Case Officer: Hannah Kersley
Reference: AW/55/22/T
Location: 48 Fish Lane, Aldwick, PO21 3AH
Proposal: Fell 25no. Leyland cypress trees
Reason given: Increasing vulnerability to storm damage, safety concern

TPO for 48 FISH LANE, PO21 3AH

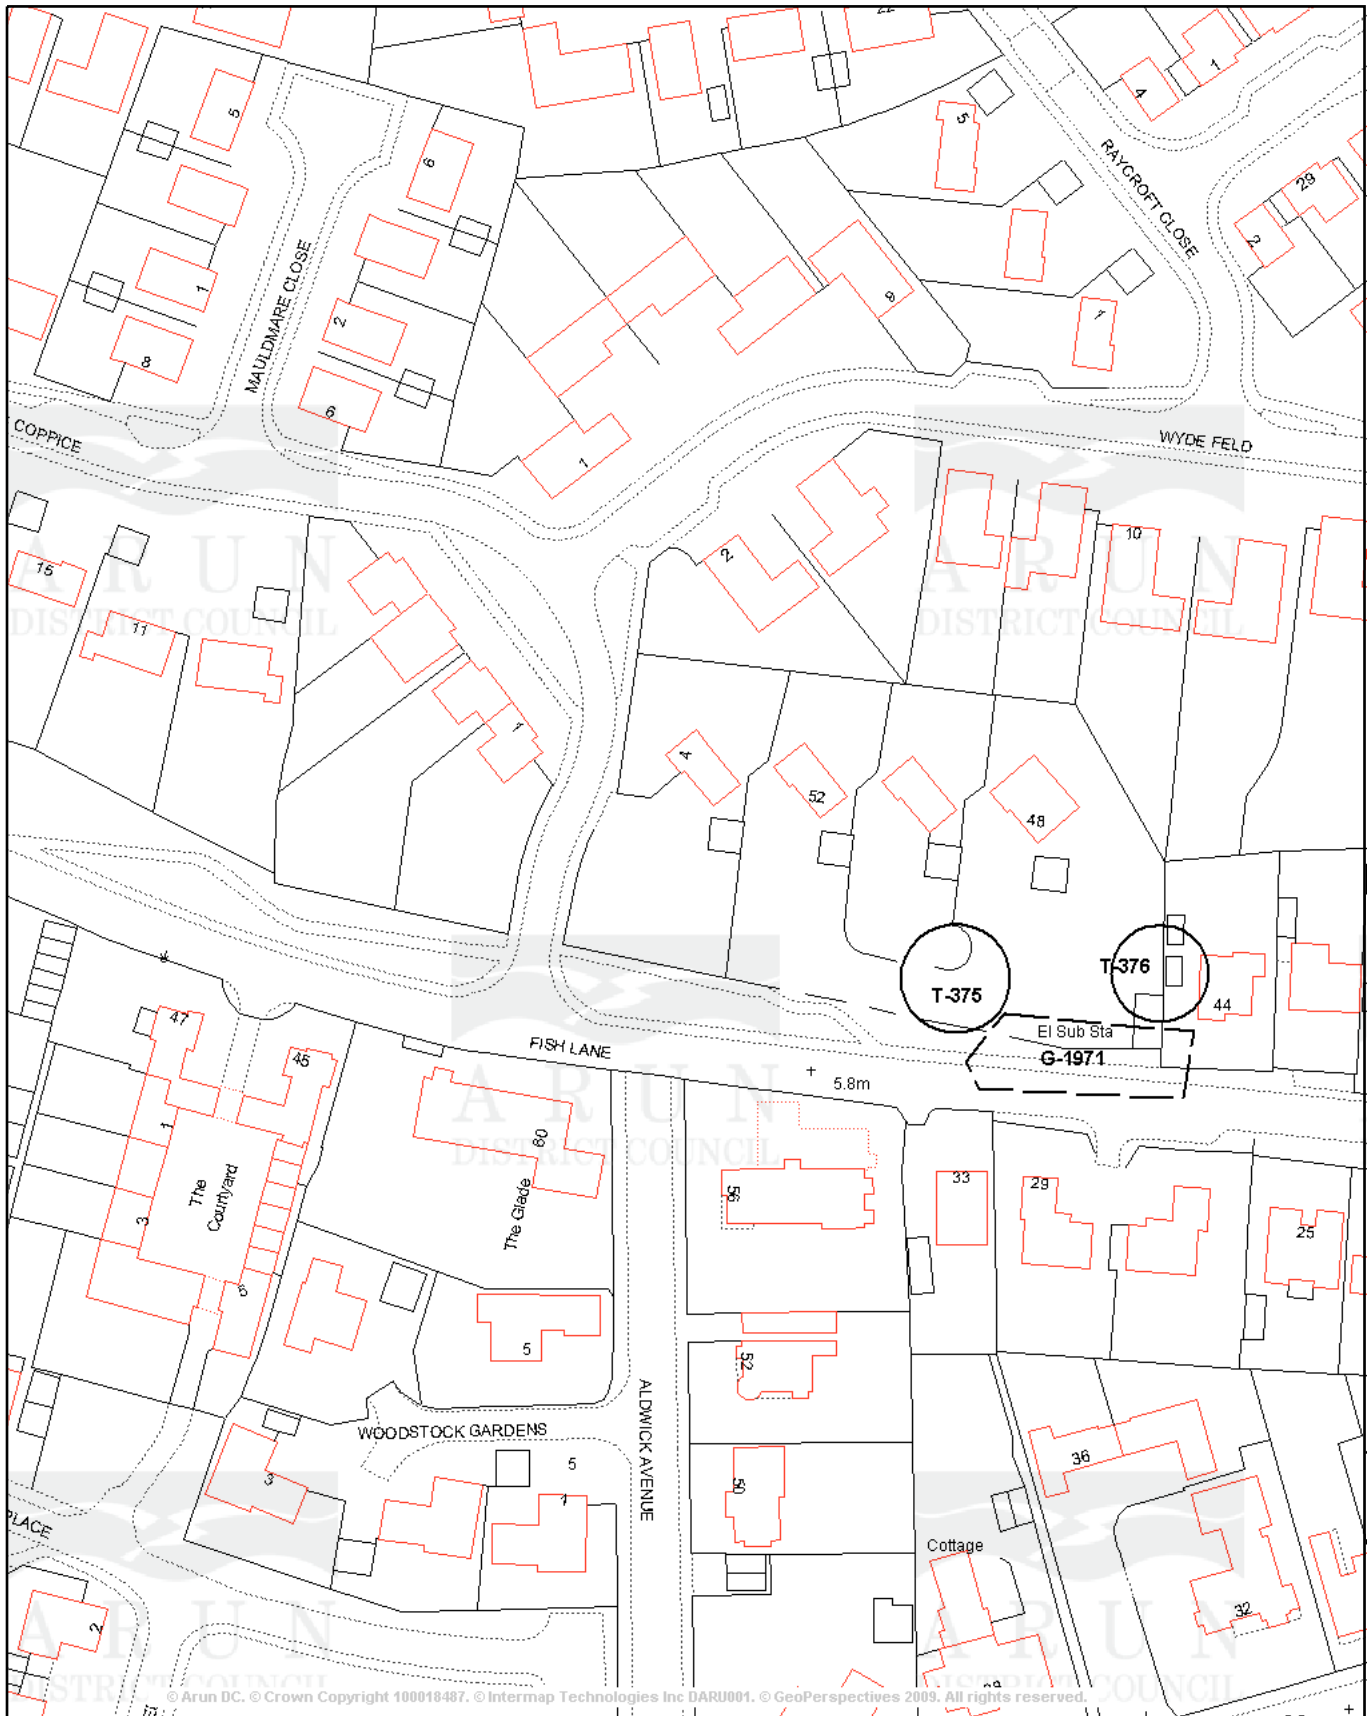
- TPO/AW/106/10 (G-1971) applies to eighteen trees in this linear group of same species, although there are approximately twenty-seven individual stems in total. From the map associated with the Order, those first eighteen trees or so due west from the east boundary are the most likely subjects. It is possible that the intention was to protect those trees of larger stem diameter although that is not stated within the TPO documents.

- A reasonable and logical position to take is that all trees are protected due west from the east boundary until the first obvious gap (see embedded photo at foot of this report). That closely resembles the group extent as illustrated on the TPO plan. Those trees west of the gap have less average height and stem diameter than the majority east of same.

- The planning authority need only concern itself with those trees east of the gap. Consent should not be required for any proposal affecting nor any condition exist to ensure replacements for, those trees west of the gap.

Once the trees have been felled (and either grubbed or ground out) then five replacement trees are to be planted in the same place (or nearby and to within three metres) to form a new linear scheme at three metre spacing.
